**Office of
Environment
& Heritage**

DOC18/520859
SSD 7317 MOD12

Notification of modification to amend the approved landscape masterplan and signage strategy for Australian Technology Park (SSD 7317 MOD12)

Attachment 1 – Office of Environment and Heritage (OEH) comments - Australian Technology Park (SSD 7317 MOD12)

WELLNESS PARK PLANTING PLAN | 1:400 @ A3

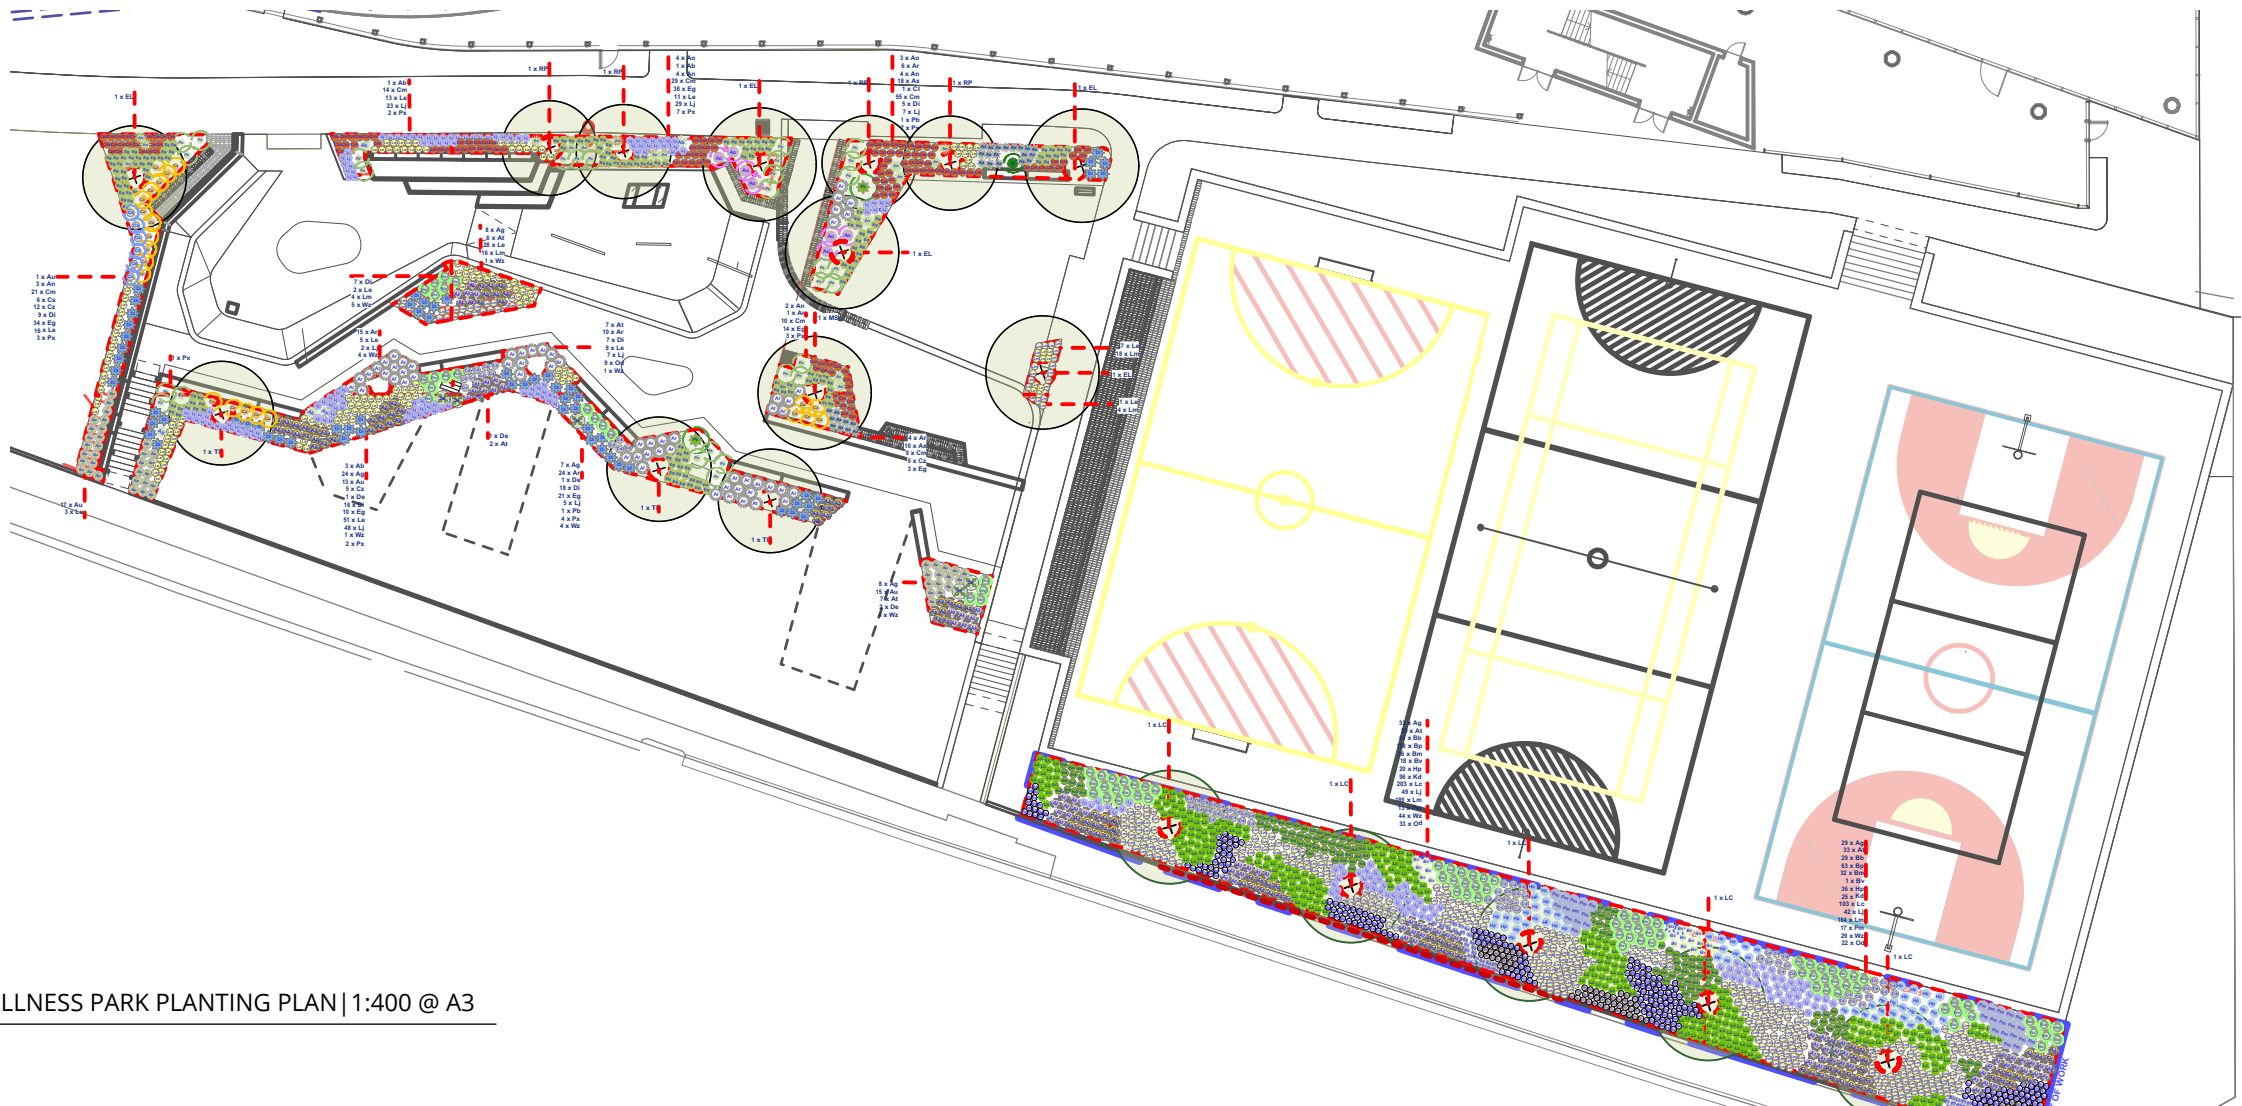
OEH recommends that the Wellness Precinct planting plan shall include native plant species and refer to the City of Sydney recommended indigenous species list.
